From: Jeff Watson
Sent: Wednesday, October 01, 2014 11:58 AM
To: 'Ginger Weiser'
Subject: RE: LP-07-00055 Schmaus 4

From: Jeff Watson
Sent: Wednesday, October 01, 2014 11:00 AM
To: 'Ginger Weiser'
Subject: RE: LP-07-00055 Schmaus 4
Attachments: LP-07-00055 Schmaus 4 Comments KRD.pdf; LP-07-00055 Schmaus 4 Approval Resolution 2008-171.pdf

**SCHMAUS No. 4 PLAT**  
PTN. SW1/4 OF SECTION 21, T.20N., R.14E., W.M.  
KITITAS COUNTY, STATE OF WASHINGTON

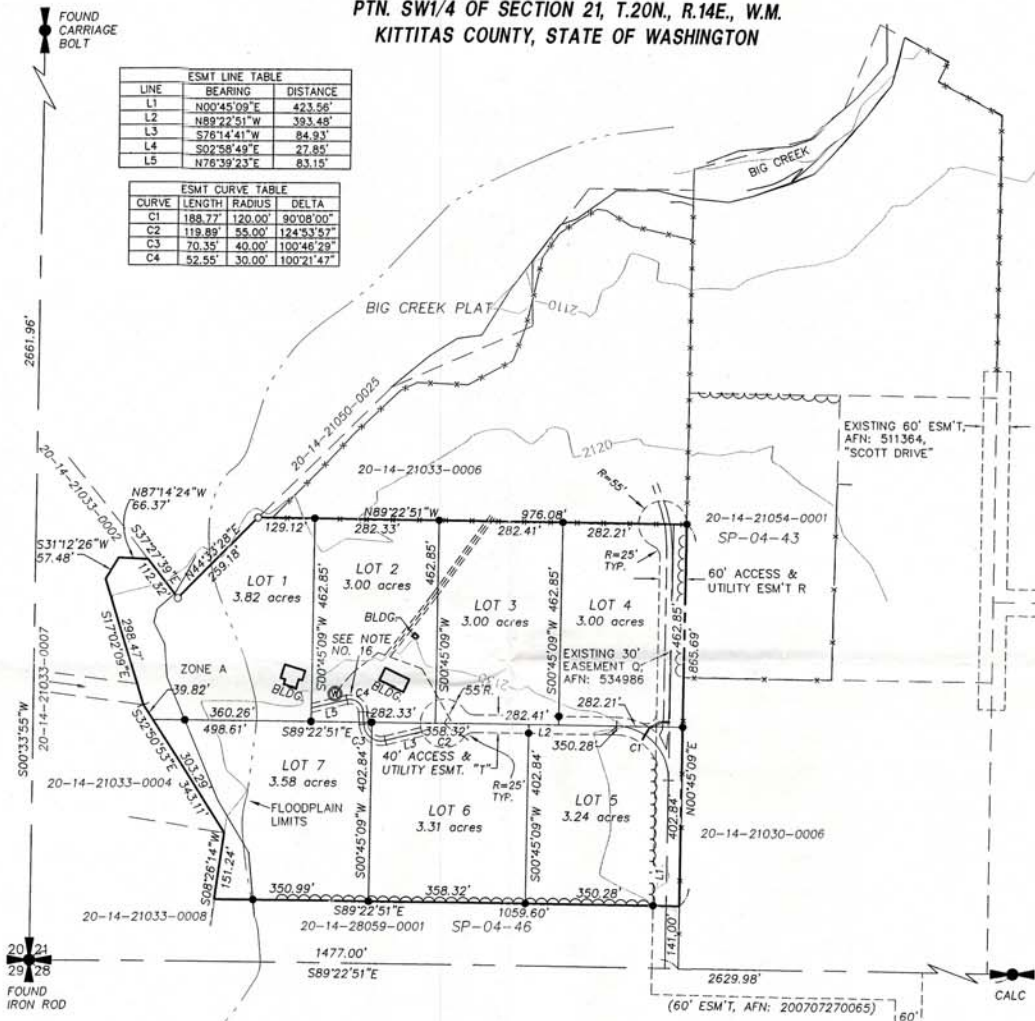
1. #6 of conditions of approval (as well as KCC 16.20) requires adjoining property owners, map #s, etc. on the mylars.
2. #6 of approval resolution findings mandates that the MDNS shall be conditions of approval.
 - a. MDNS II-B Requires a fugitive Dust Control Plan.
 - b. MDNS VII-B requires consultation with the SD and location of school bus stop on the mylars.
